Your Ref: OWQC25176
Our Ref: BE/117/19/HH
Please ask for:
Amber Willard

Town & Country Planning Act 1990 (as amended)
Town & Country Planning (Development Management Procedure) (England) Order 2015

Drop kerb to front of property with works to existing wall.
29 Westfield Bersted

South east elevation as proposed and showing works to wall 1:100

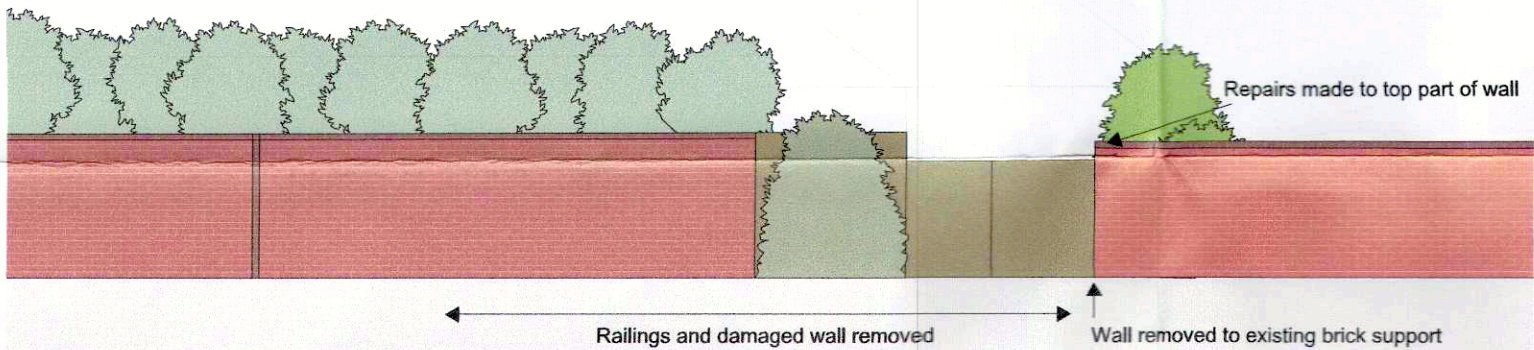
Visual Impact the proposed works will disrupt the visual impact of the wall that surrounds this development along Rowan Way from Clydesdale Gardens to Sunningdale Gardens and will set a precedent for other households to apply for direct access off Rowan Way.

Site plan as proposed showing visibility splay 1:500

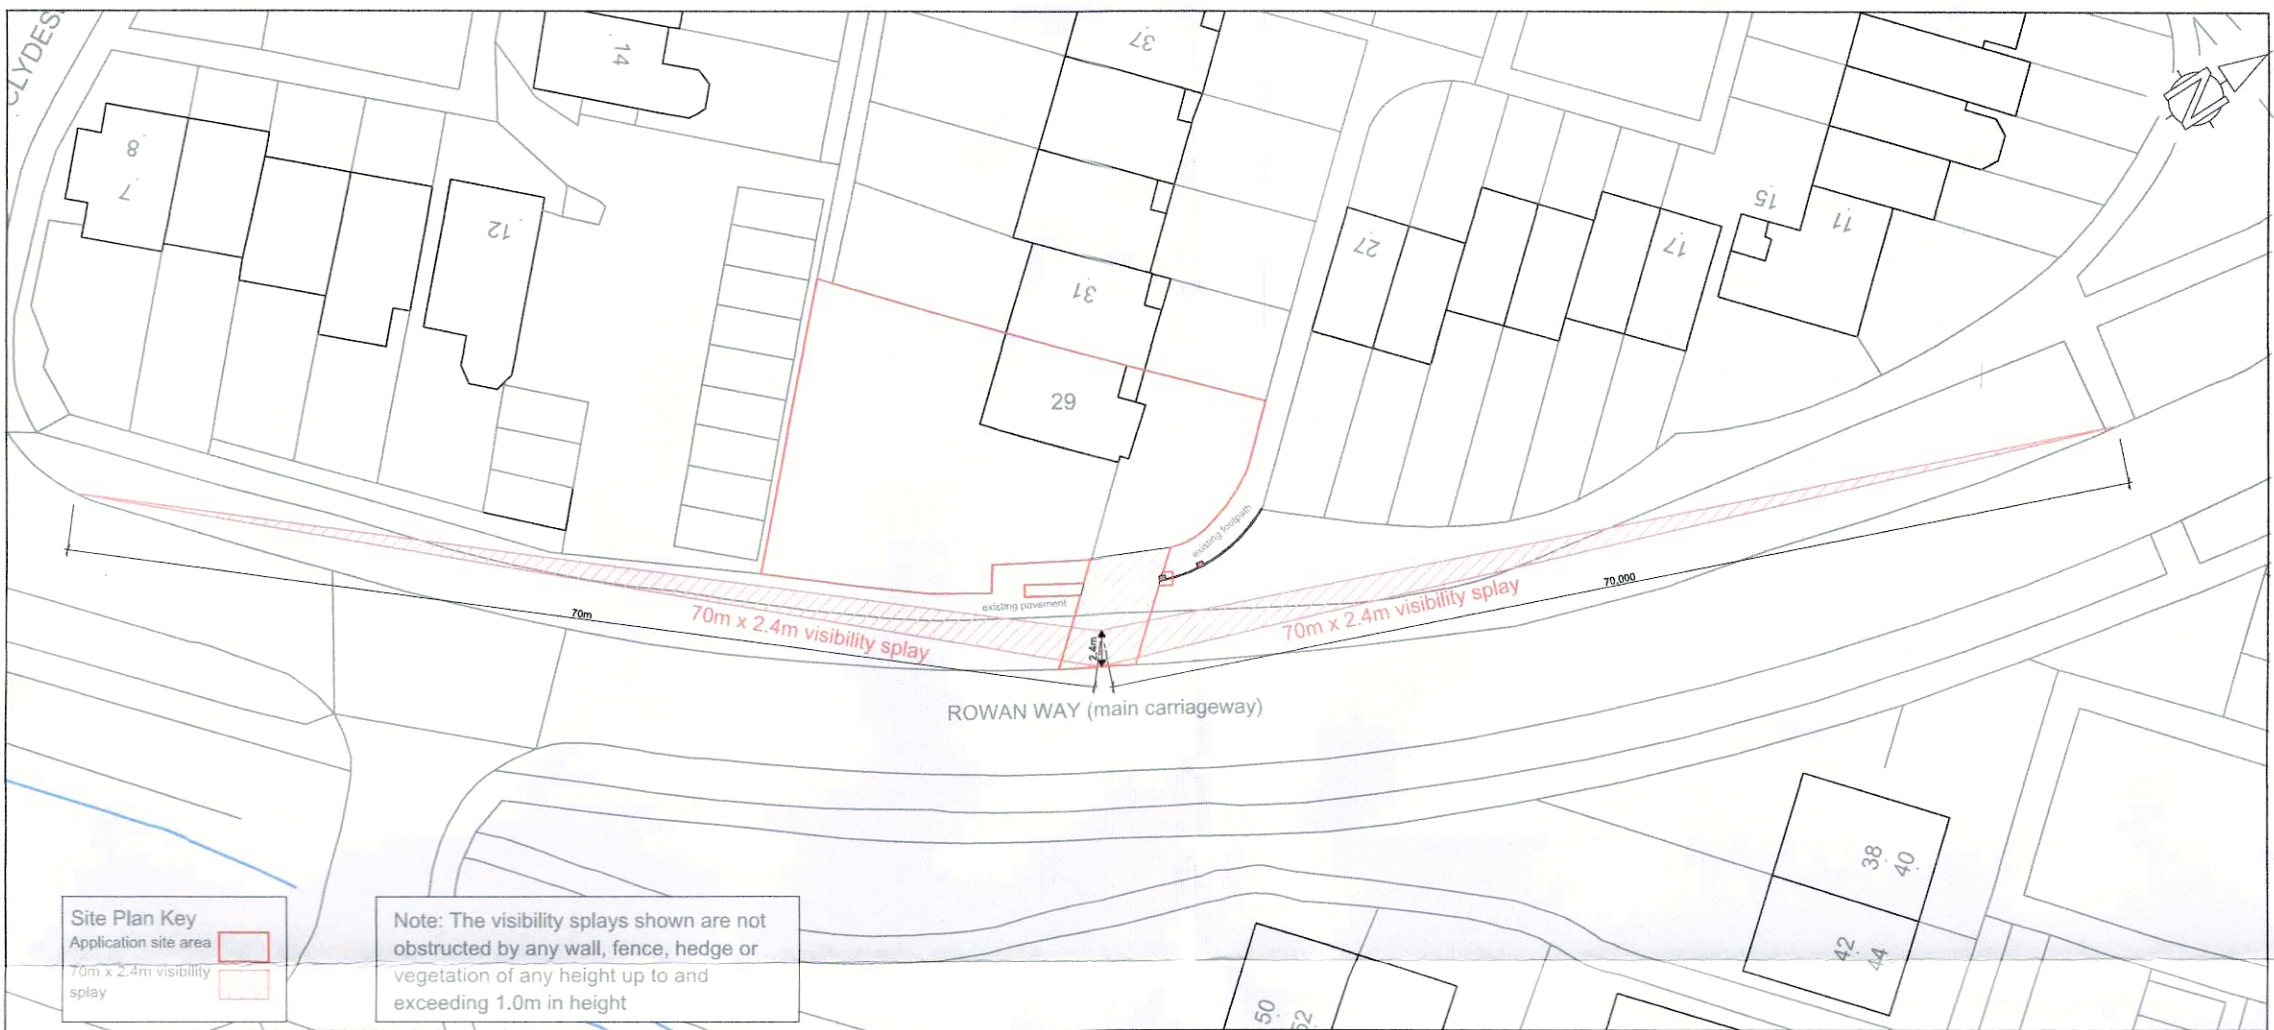
Highway safety & access off Rowan Way restricted visibility for vehicles driving along Rowan Way with vehicles entering and exiting this proposed entrance to access 29 Westfield off Rowan Way. Safety of pedestrians using the footpath on Rowan Way and accessing the footpath leading into Westfield at this point, where proposals are to demolish part of the wall. If this was to be approved by Arun DC Planning, then clear markings need to be used to inform cars travelling along Rowan Way of this exit and for pedestrians to be made aware of vehicles crossing the footpath.
